**Grandview Lift Station - General Comments - Submittal 1 Comment Response**

Subject	Comments	Author	Date	HR Green Response
Public Health	The proposed new lift station must meet the permitting requirements and the design criteria for lift stations of the Colorado Department of Public Health and Environment (CDPHE), Water Quality Control Division (WQCD).	Mike McCarthy (El Paso County Public Health)	8/30/2024	Acknowledged
Public Health	Please verify if the new lift station requires or has previously received approval of the Site Application Review Committee (SARC), the Water Quality Management Committee (WQMC), and the Pikes Peak Area Council of Governments (PPACG).	Mike McCarthy (El Paso County Public Health)	8/30/2024	Approval Received 6/24/24
General	MVEA has existing facilities near and within this parcel of land. If there is any damage, removal or relocation of facilities it will be at the expense of the applicant	Mountain View Electric Association, Inc. (MVEA)	7/31/2024	Acknowledged

SHEET
 C101

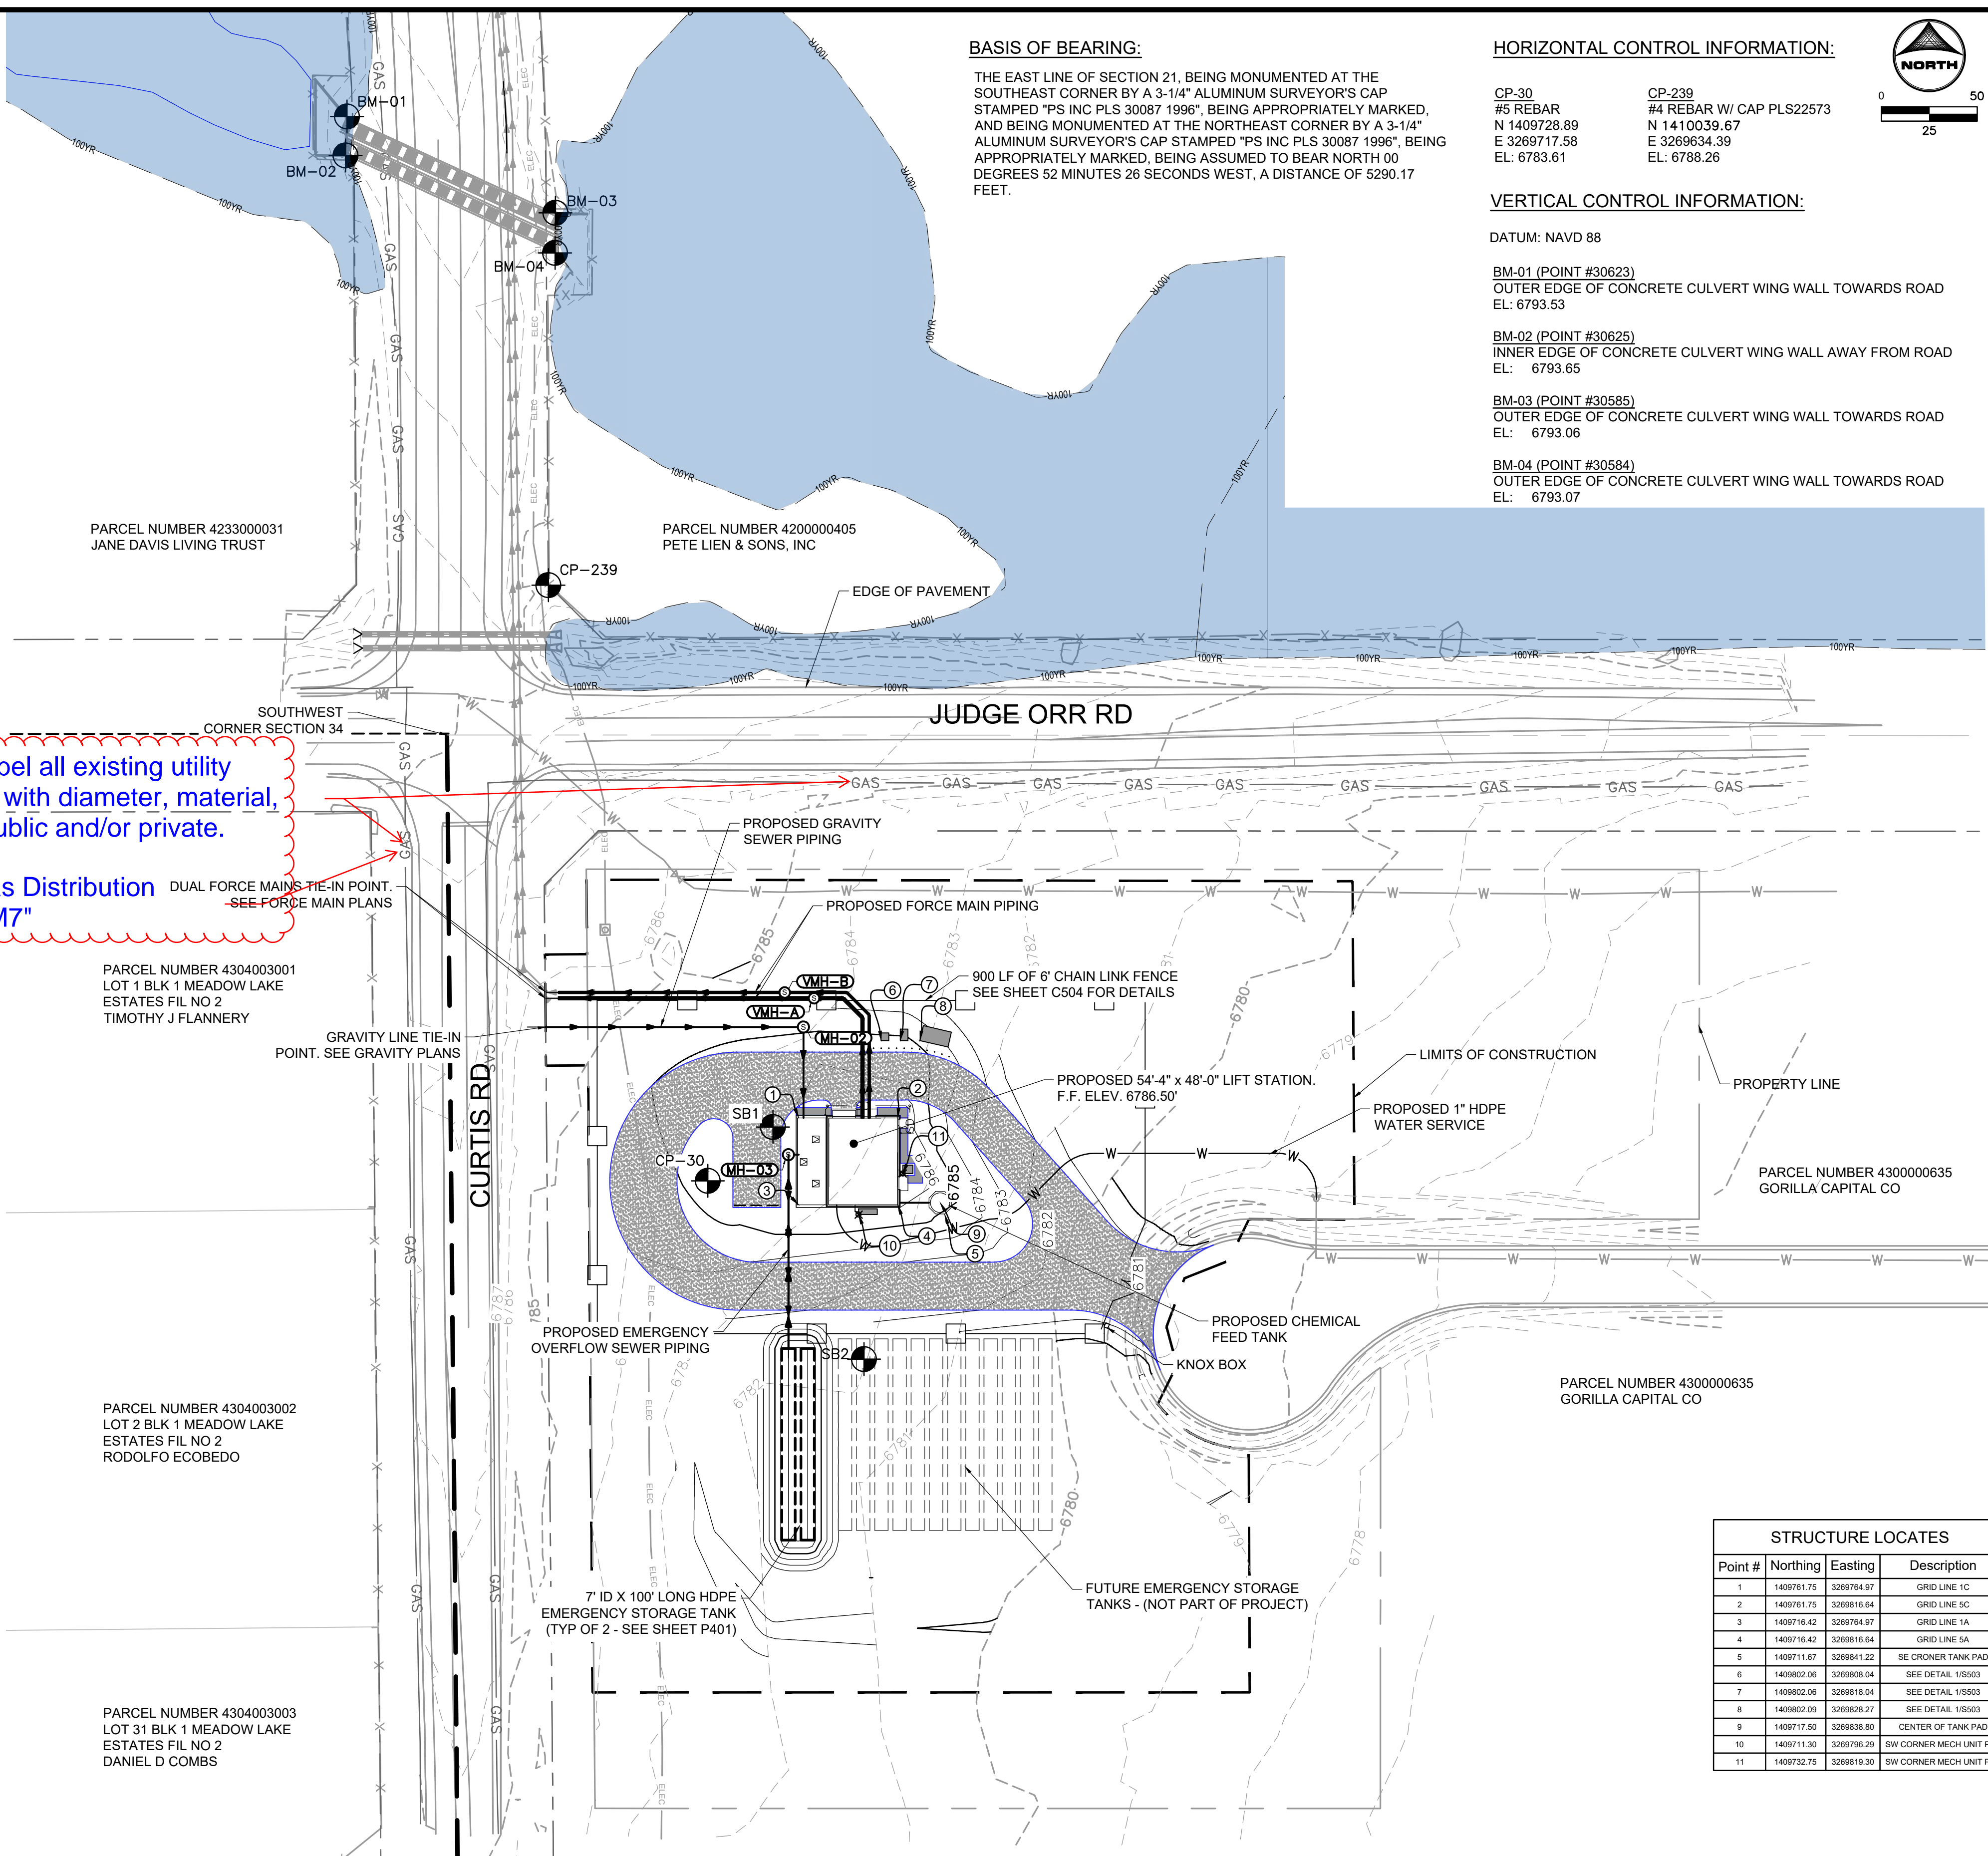
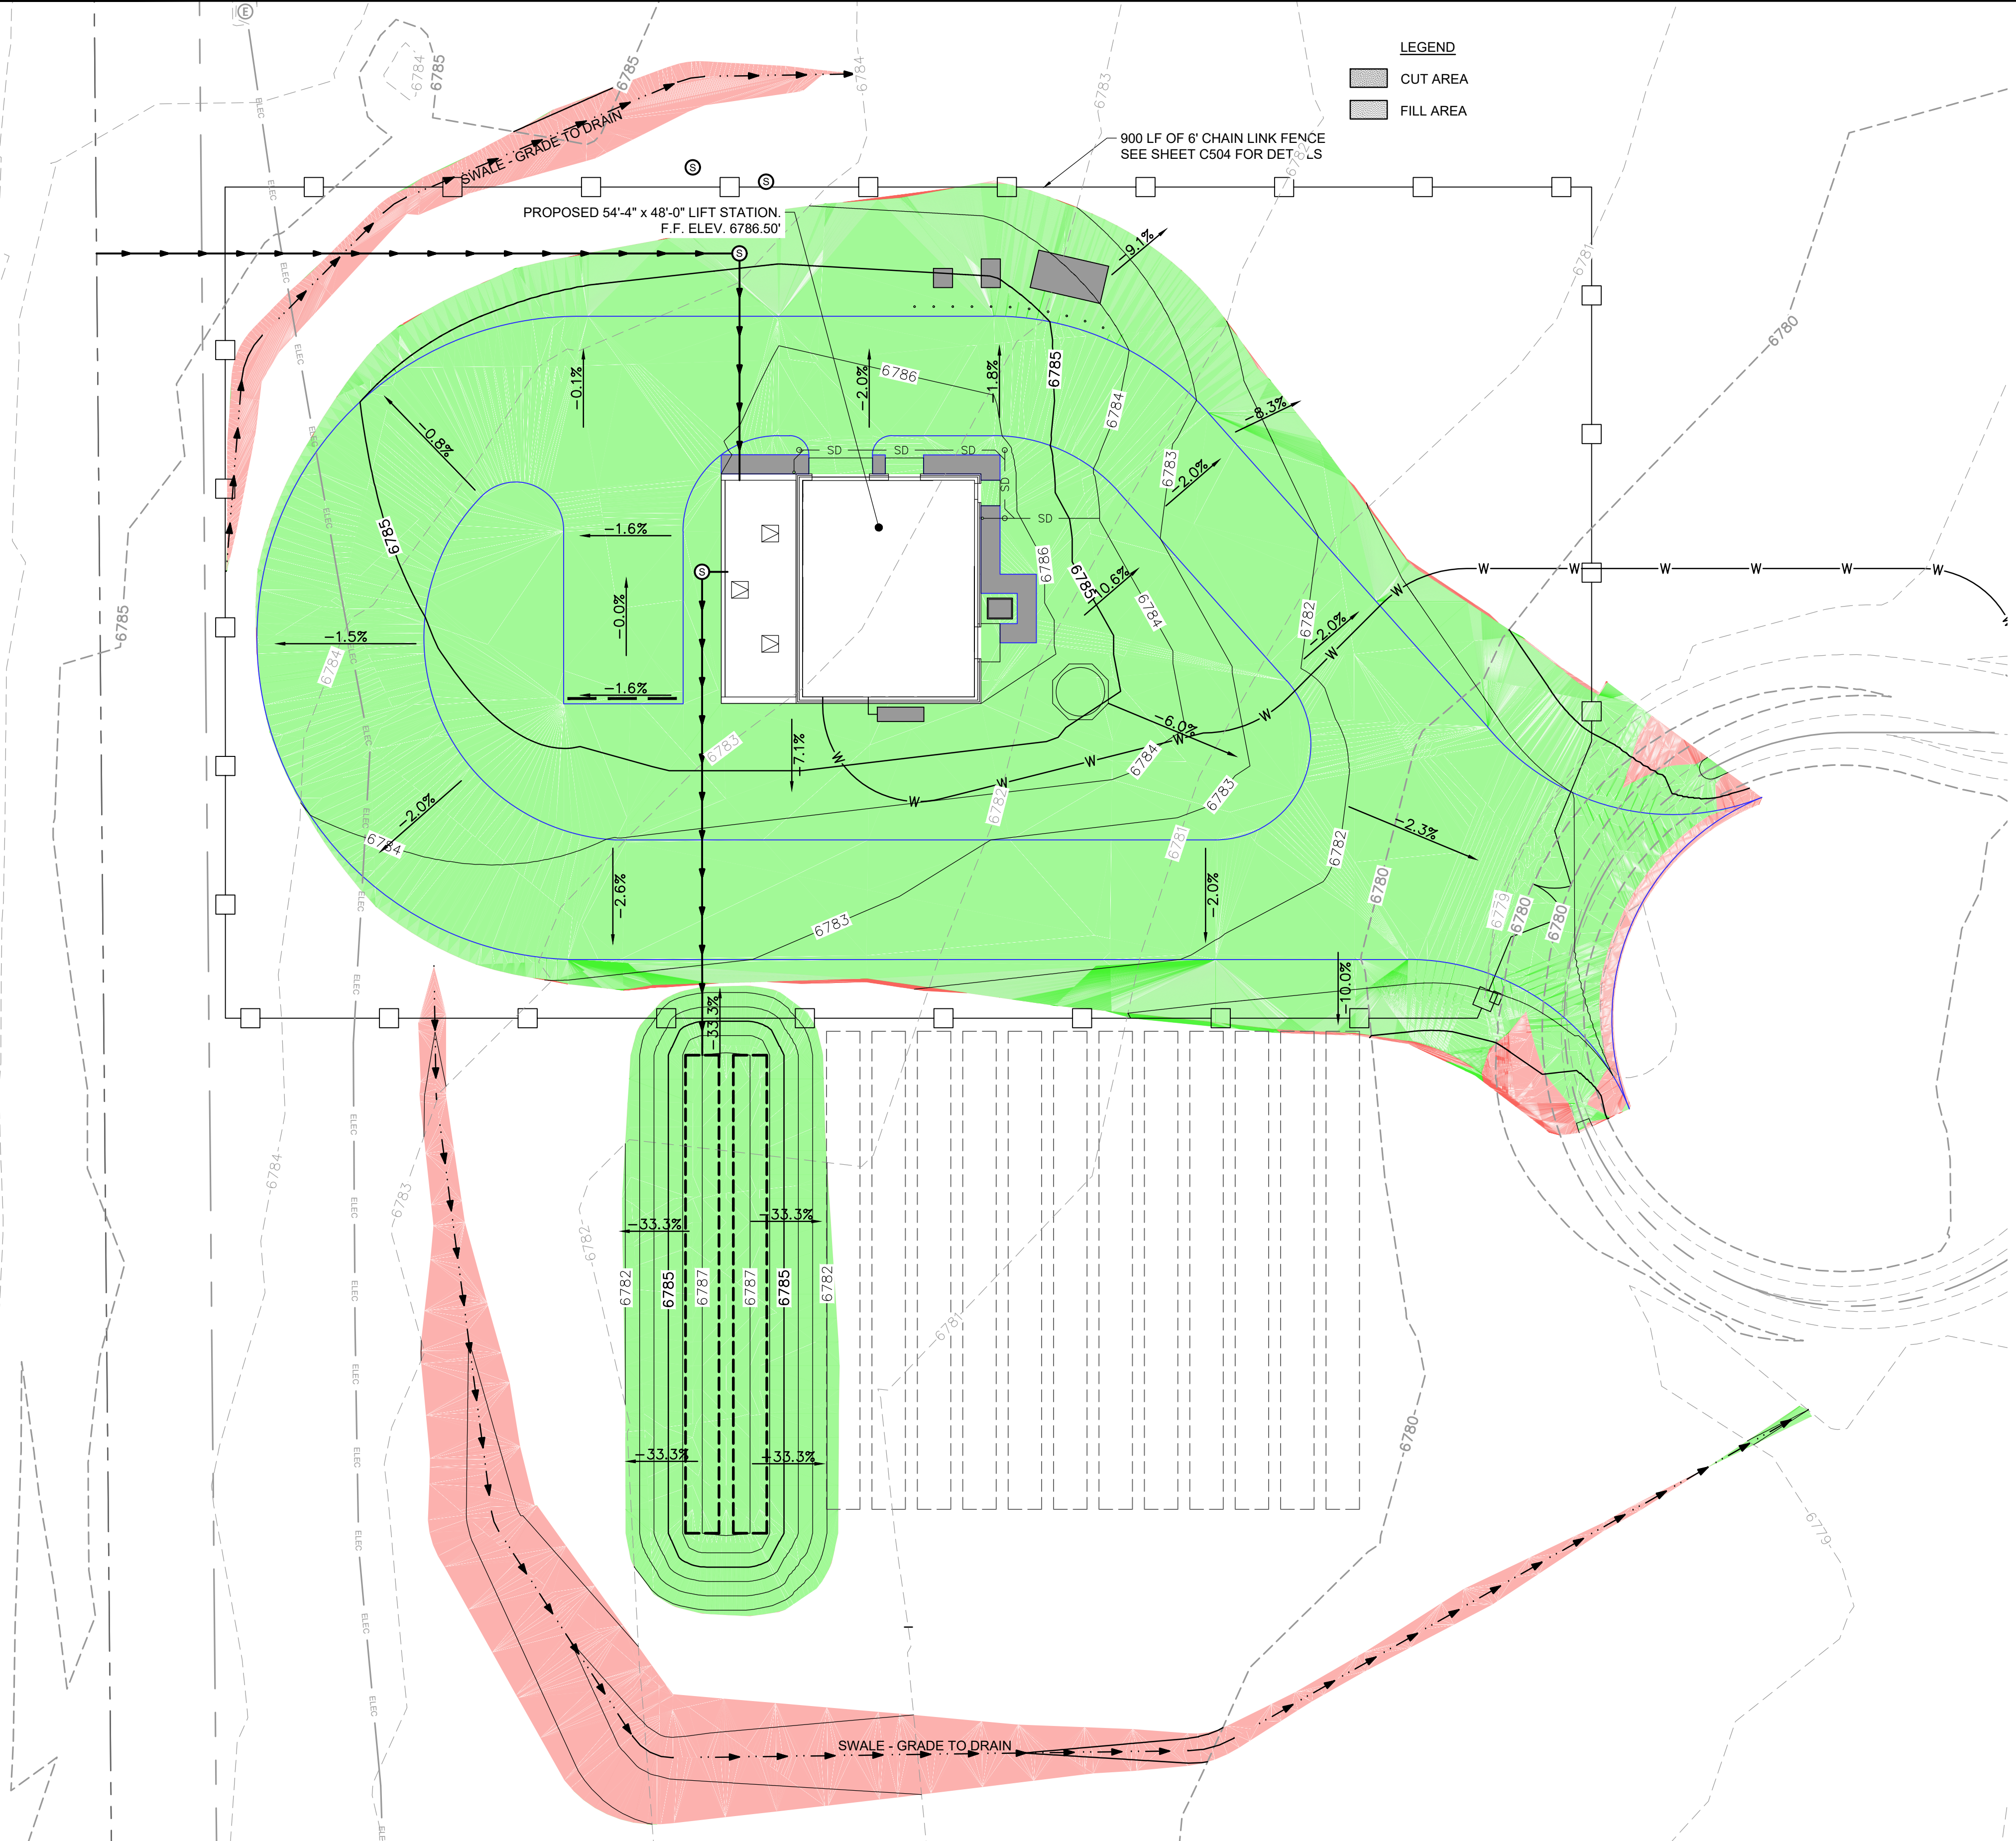
General	Show and label all existing utility service lines with diameter, material, and either Public and/or private. Label as "Gas Distribution Main: AE19M7"	Mathew Alcuran - Colorado Springs Utilities Dev, Svc	7/26/2024	Information is not available at this time
General	No new streetnames requested on this submittal. The development plan drawings does not indicate the access road name for this development. The name intended for this road is "Rocoso Trl". This name should be notated on the plans.	Justin - 911 Authority - El Paso/Teller County	7/22/2024	Corrected
General	No information was provided regarding proposed water uses or estimated water demands on the property, therefore this office has no comments on the water supply for this referral.	Colorado Division of Water Resources	7/18/2024	Acknowledged
